Reviewed for Code Compliance  
Inspections Division  
Approved with Conditions

Date: 01/20/15

# 57 COYLE STREET RENOVATION

## 57 COYLE STREET - PORTLAND, ME

A3.2

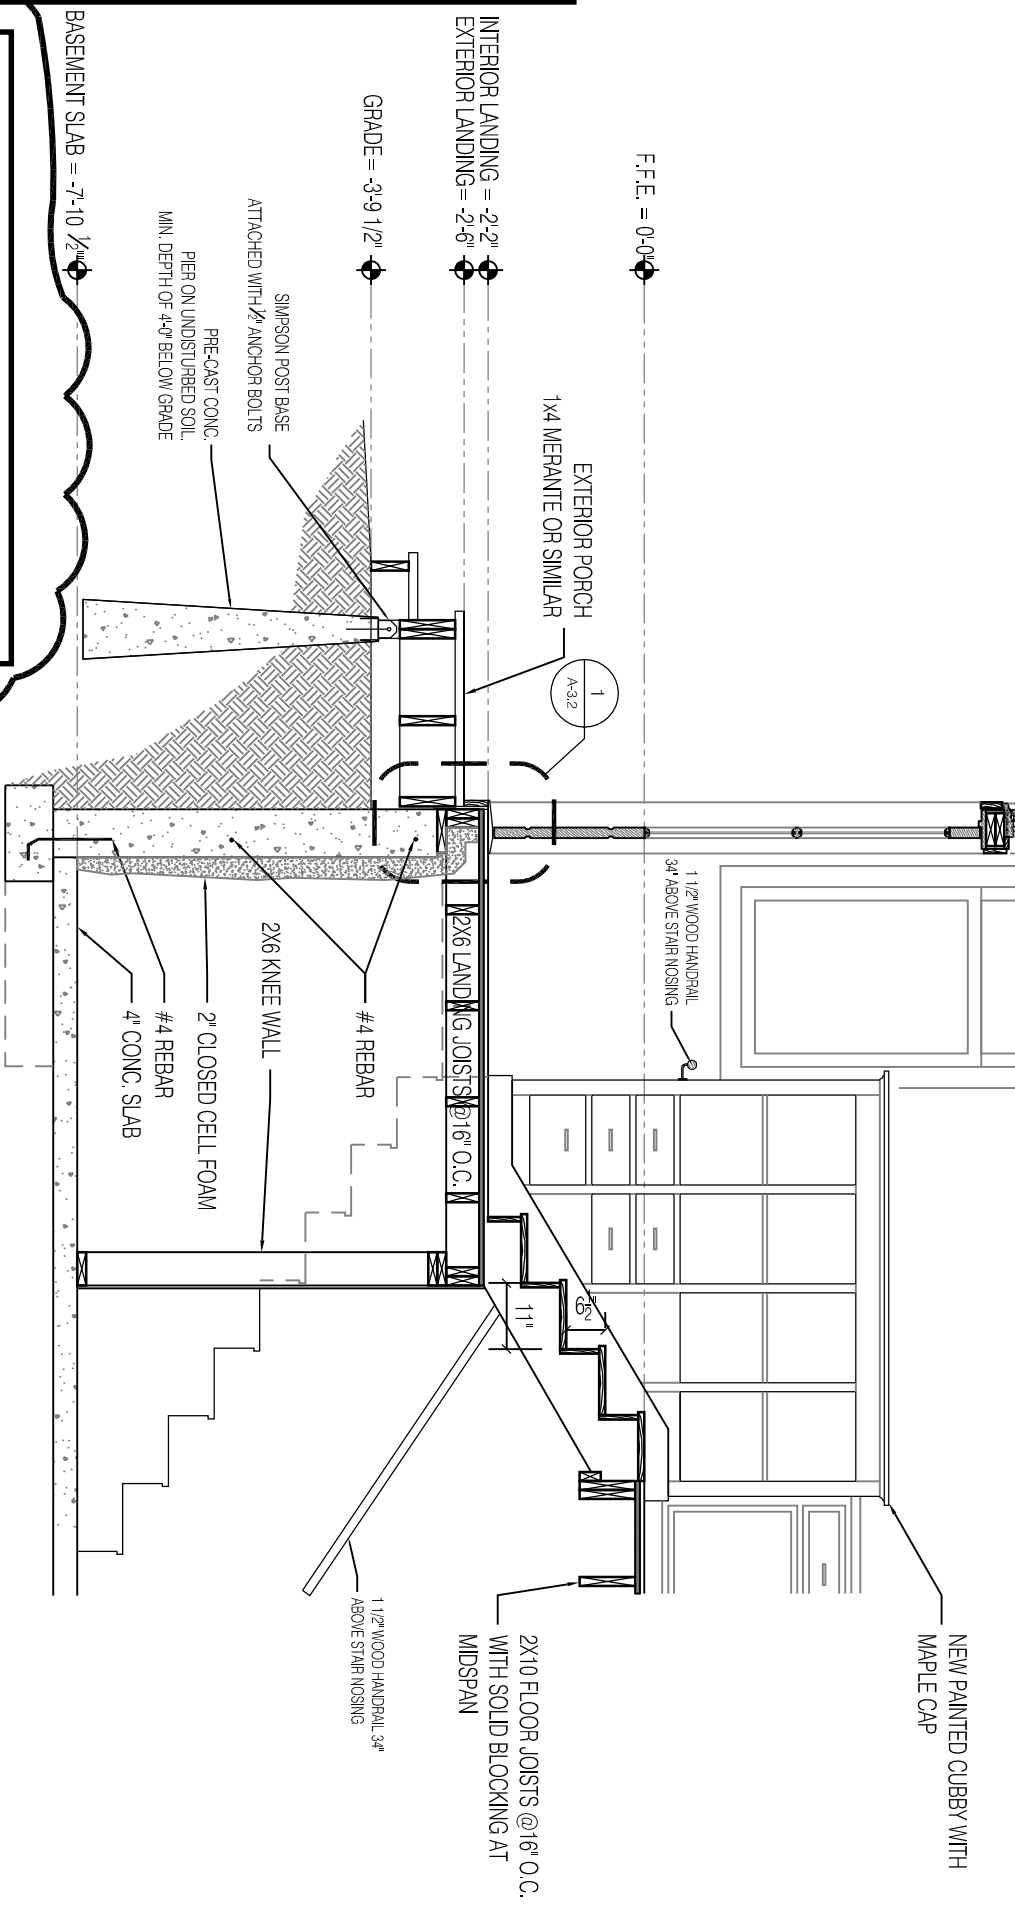
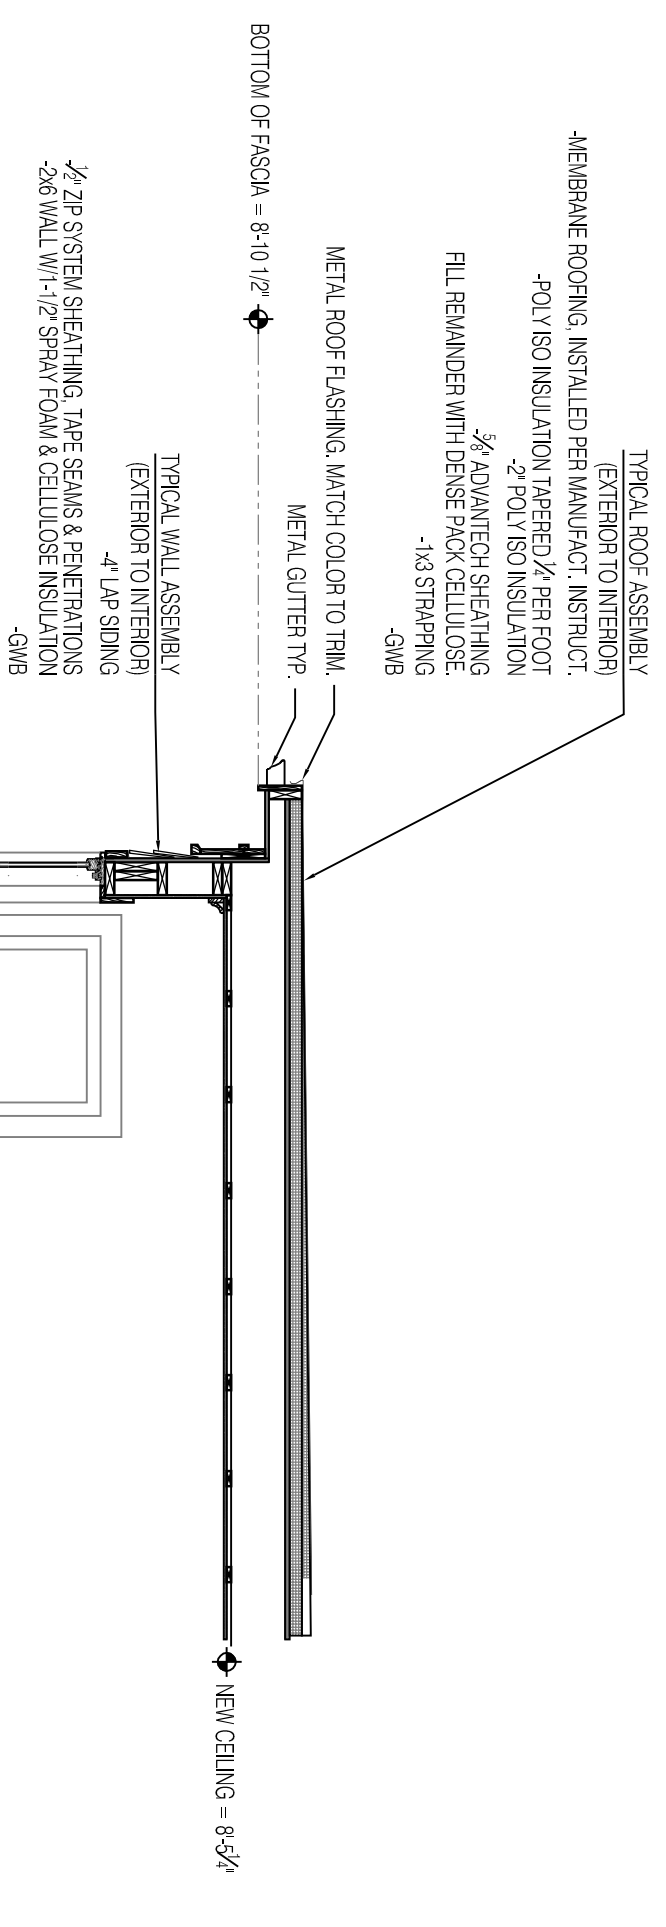
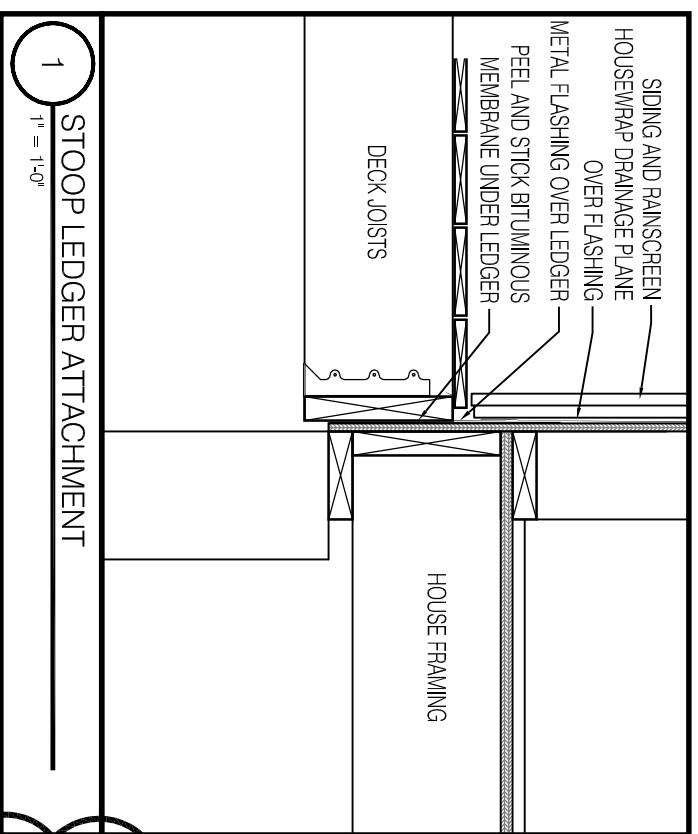
IRC Sec R311.7.4.3  
requires the nosing to  
be a minimum  
of 3/4" and a max  
1-1/4"
